Your reference: SSD 5348
 Our reference: ECM 4396078
 Contact: Robert Craig
 Telephone: (02) 4732 7593

4 November 2013

State Significant Development Application for Stage 3A Subdivision of North Penrith Defence Site (SSD-5348)

## Thornton – Station Plaza – Kiosk and Shade Canopy

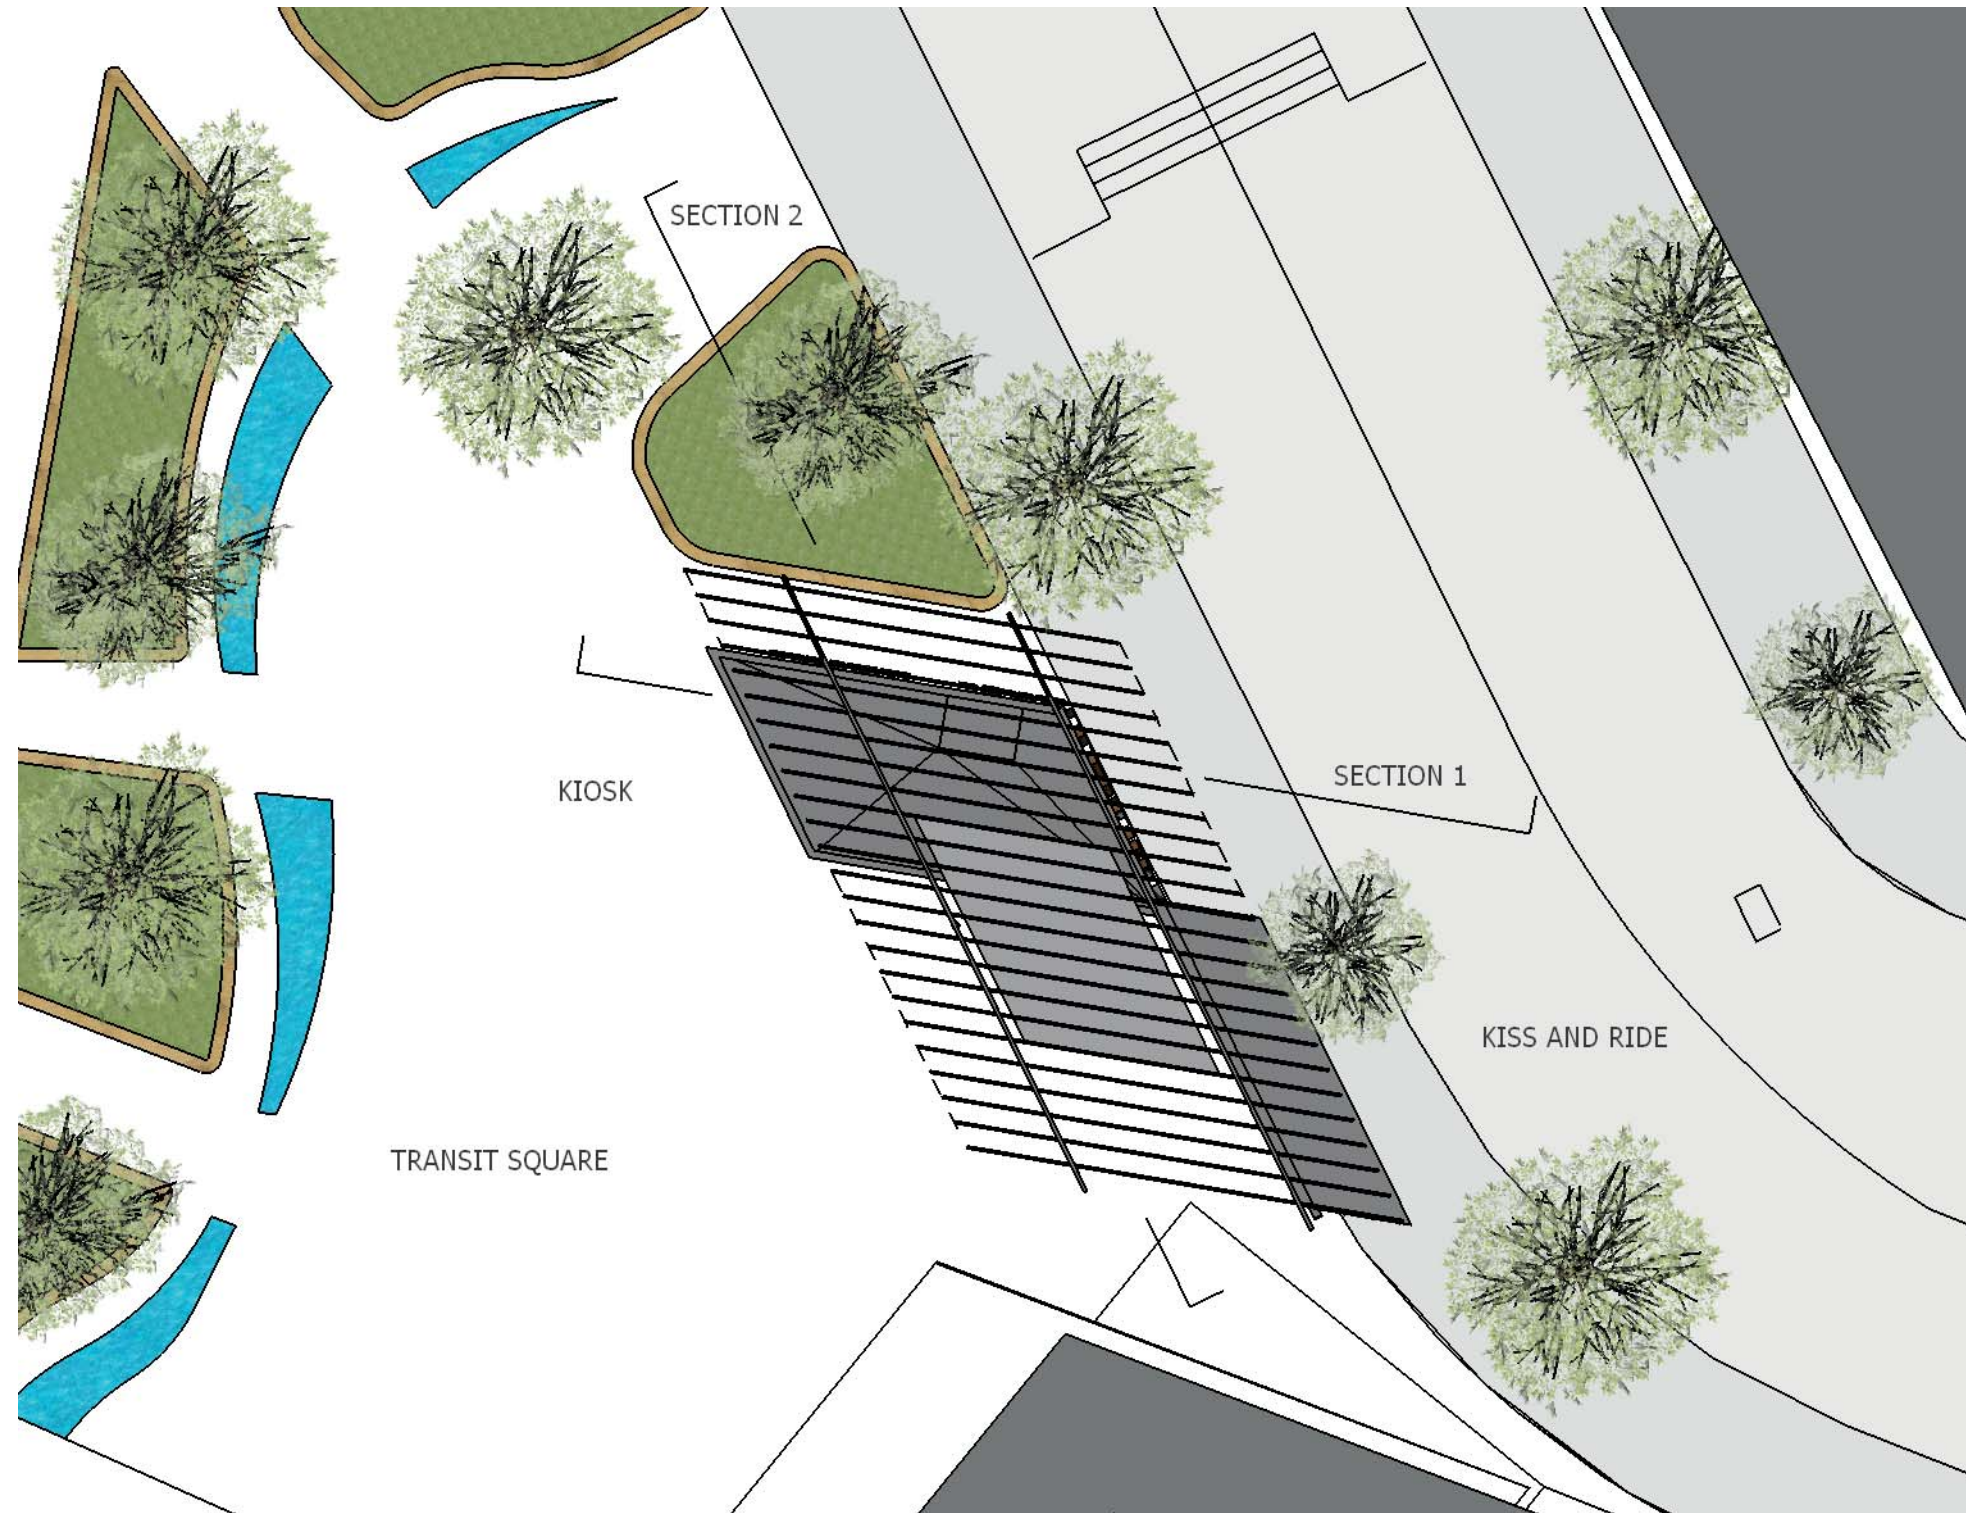
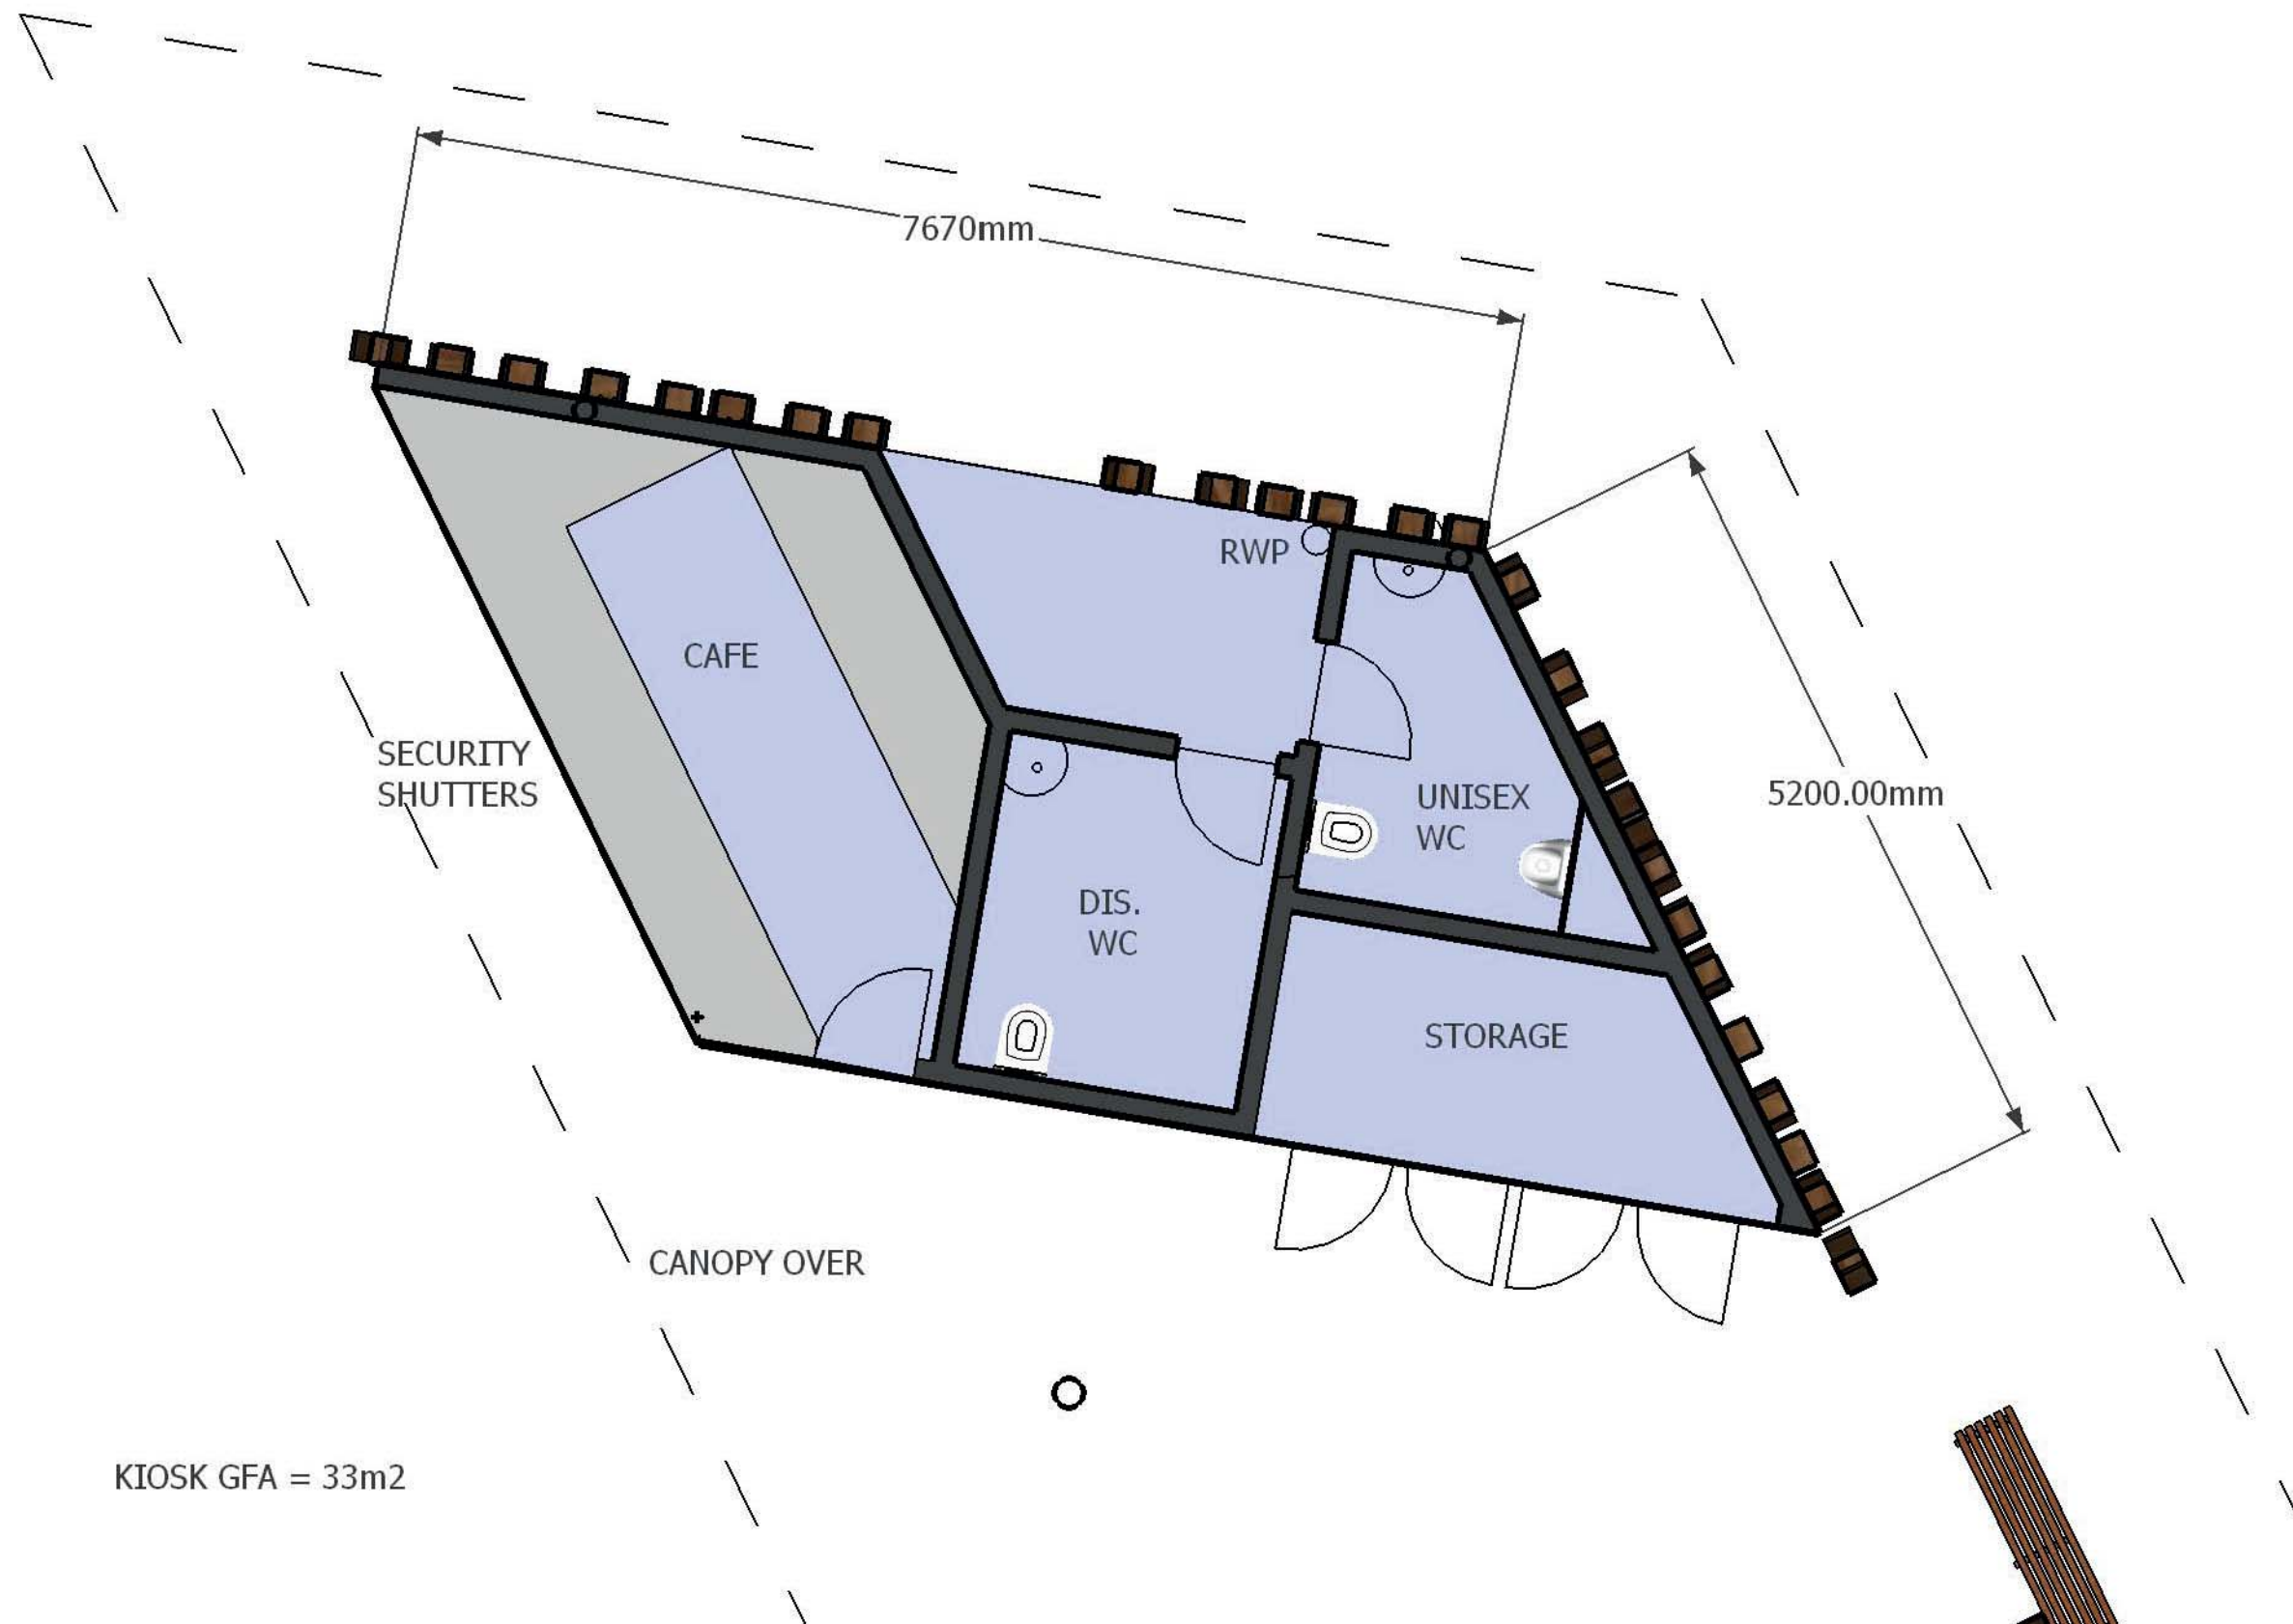
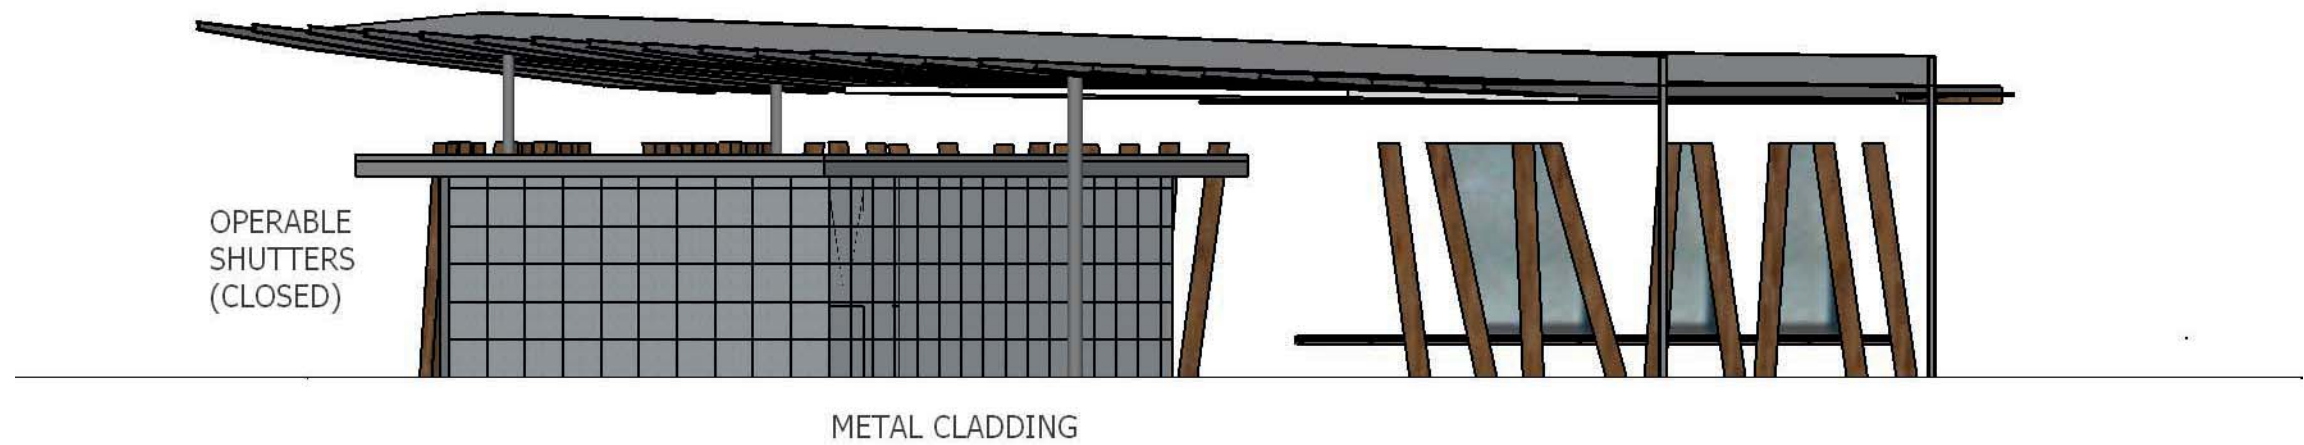
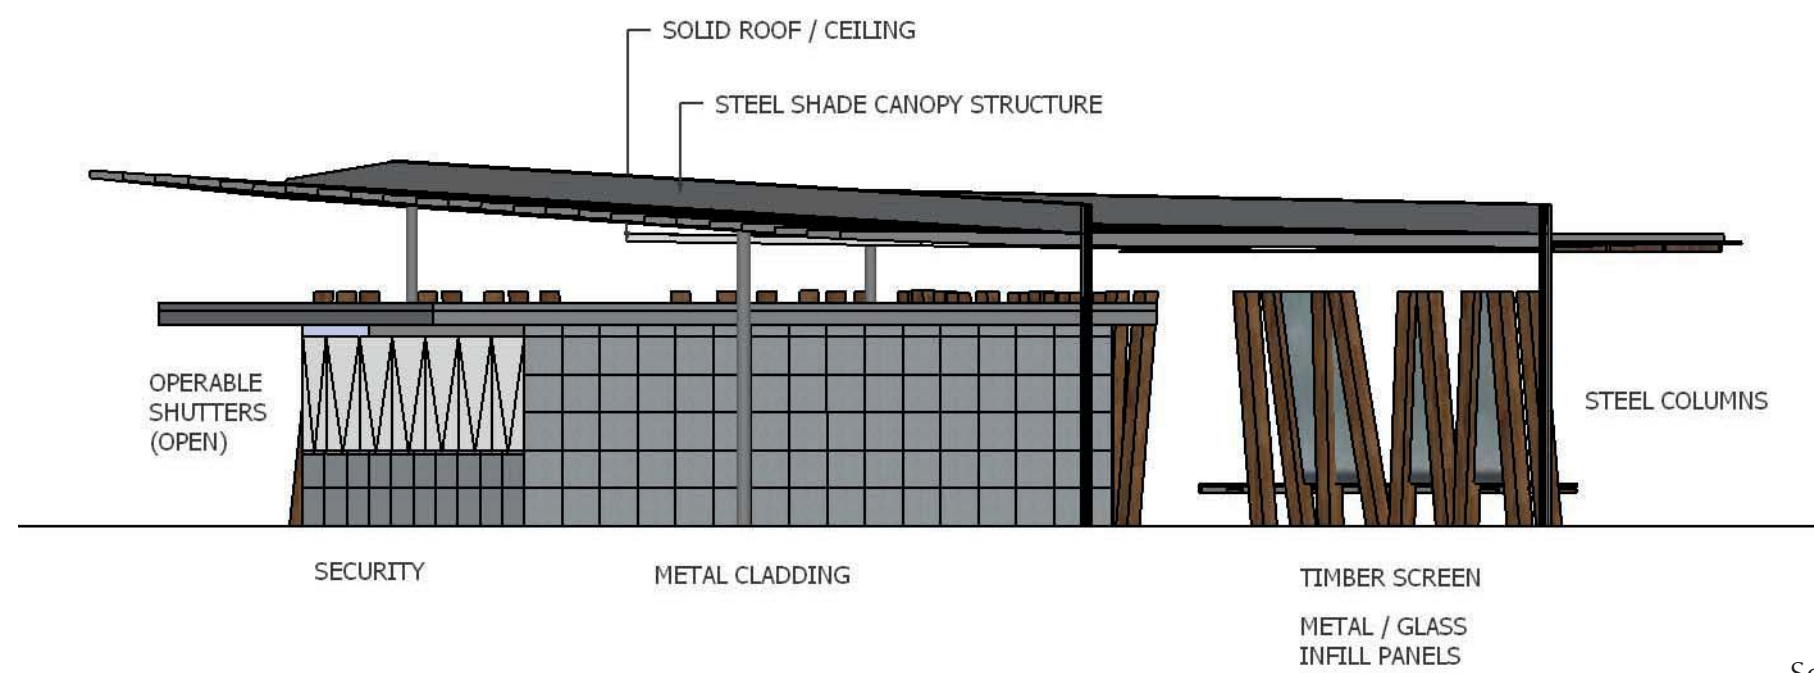
- The kiosk building (including toilets) shall be well lit with sturdy under-awning lighting provided to achieve lighting levels in accordance with relevant Australian Standards. Internal lighting shall also be provided.

- The toilet facilities shall be fitted with sturdy locks so that they can be securely locked after hours and to prevent opportunities for malicious damage. Stainless steel fixtures are recommended. MLAK locks shall be fitted to the accessible toilet to enable access only for persons with a disability.

- Toilet cubicle doors shall be fitted to remain open when not in use so that people can clearly observe the cubicle prior to entry and vice versa. These design principles have been applied in Council's own Public Toilet Replacement Program and promote safer use of public amenities.
